**14-18 BOONDAH ROAD (MP10_0177 MOD 6)
RESPONSE TO COUNCIL SUBMISSION**

I refer to Pittwater Council's letter dated the 20 February 2012, which comments upon the abovementioned modification to allow for the shared pedestrian/bike path that was recently approved by the Planning and Assessment Commission (PAC) under the Concept Plan. Each of Council's issues are addressed below.

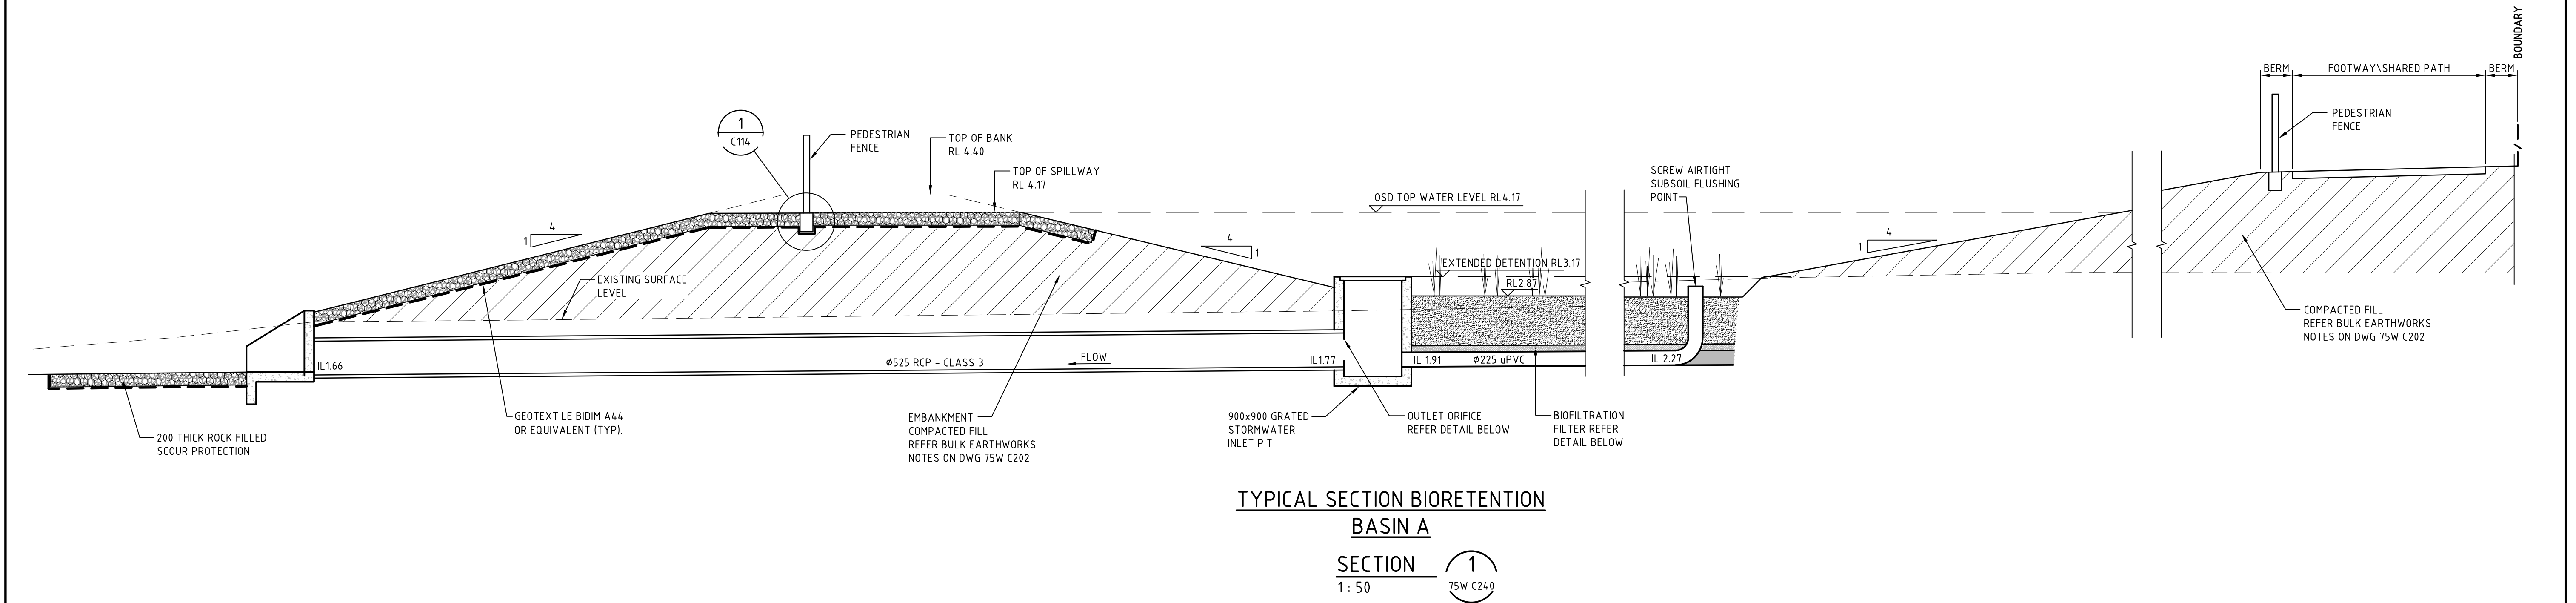
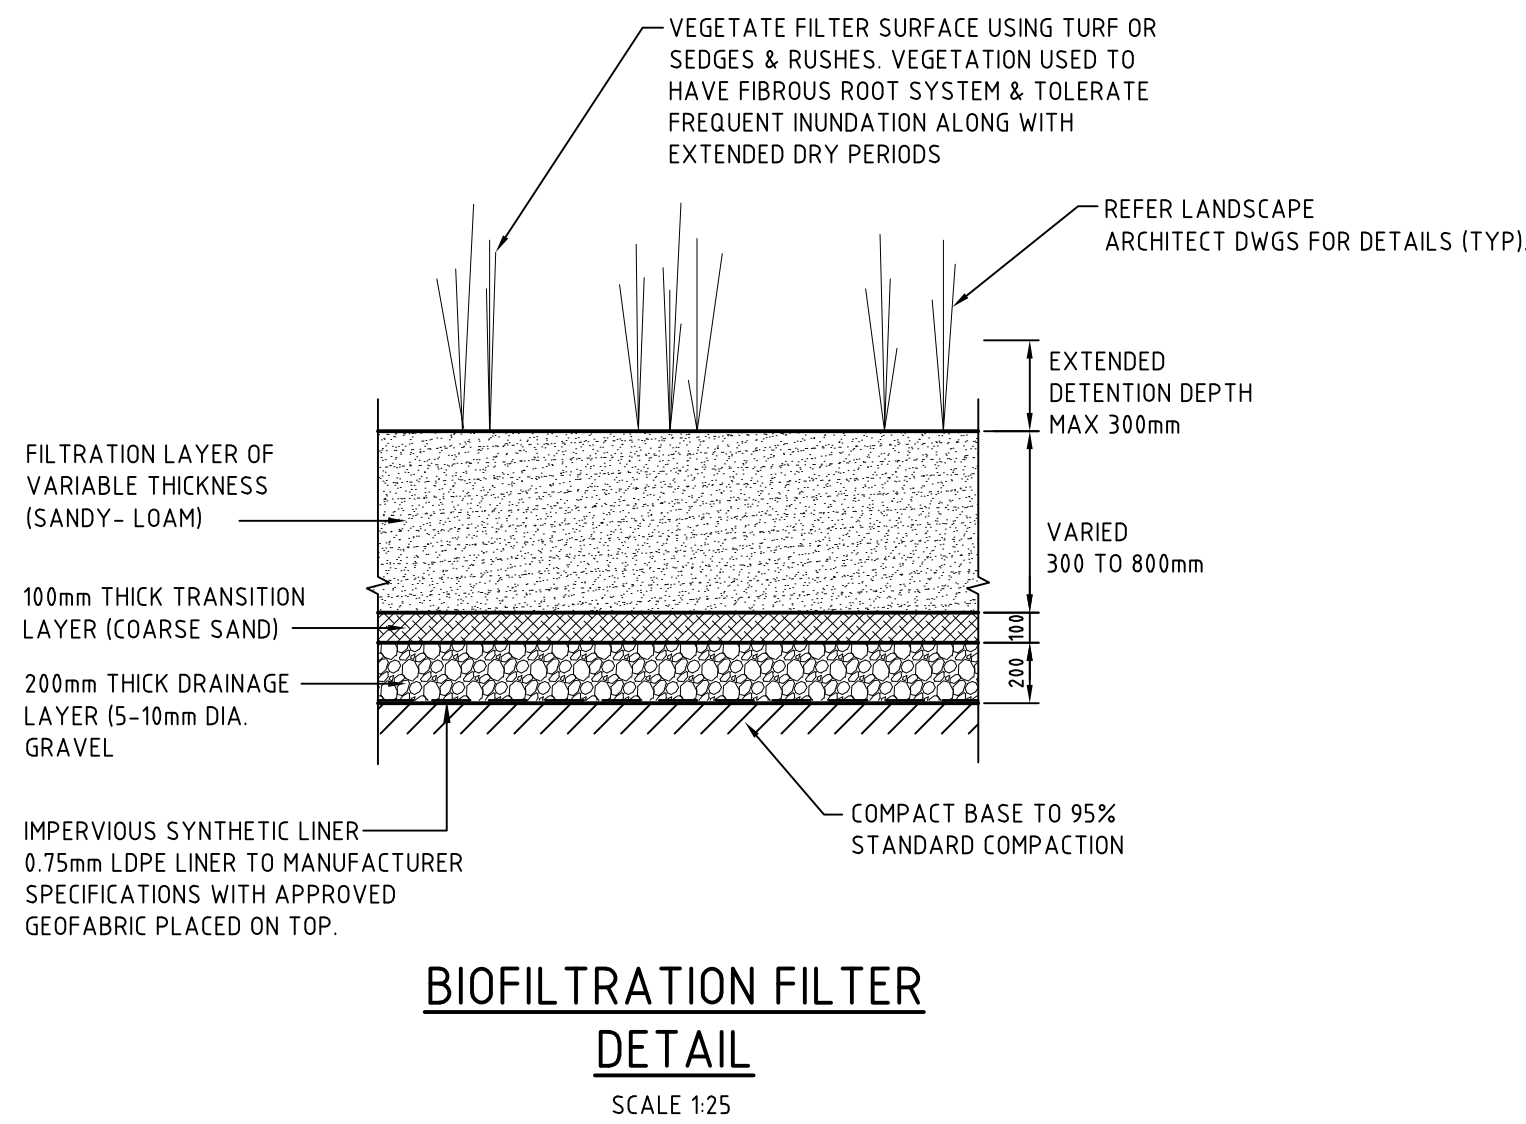
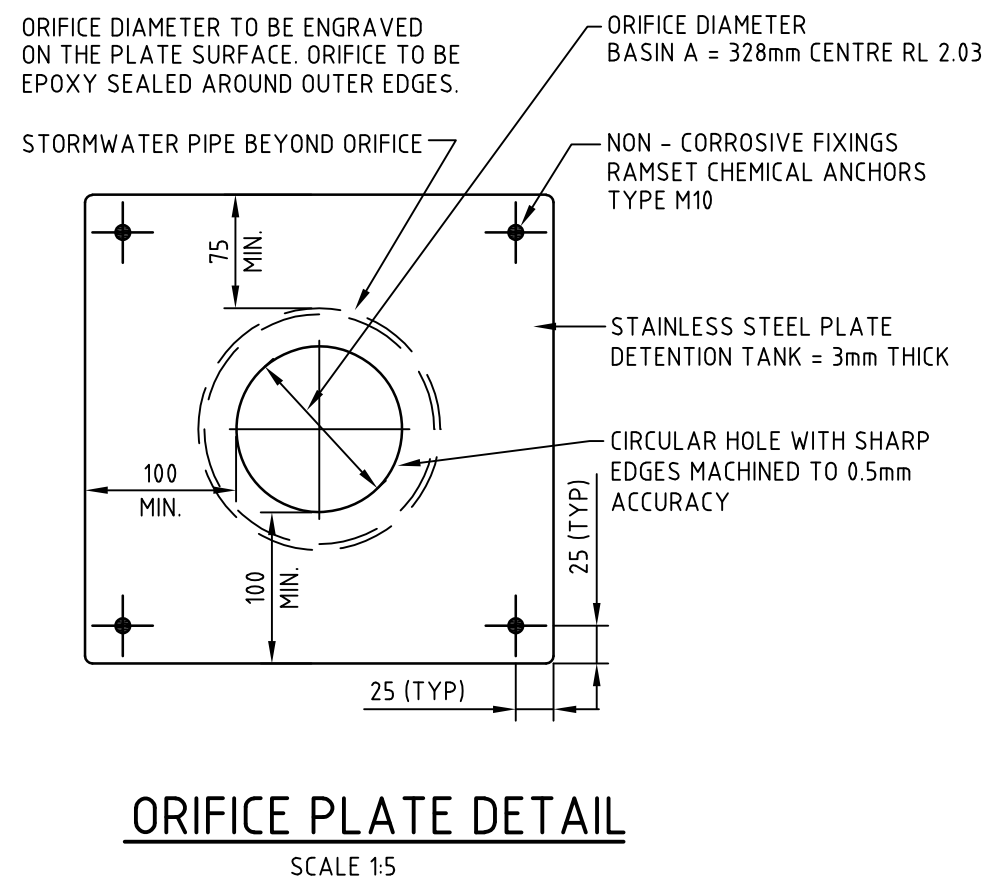
The issue with amenity of residents and bicycle users was also raised by Council during the assessment and consideration of replacing the internal road with a pedestrian/bike path when approved by the PAC. In terms of pedestrian and bike user safety, Drawing No. 75WC242 in **Annexure 8** shows a pedestrian fence proposed along the top of the regraded bio detention basin to address safety concerns of Council.
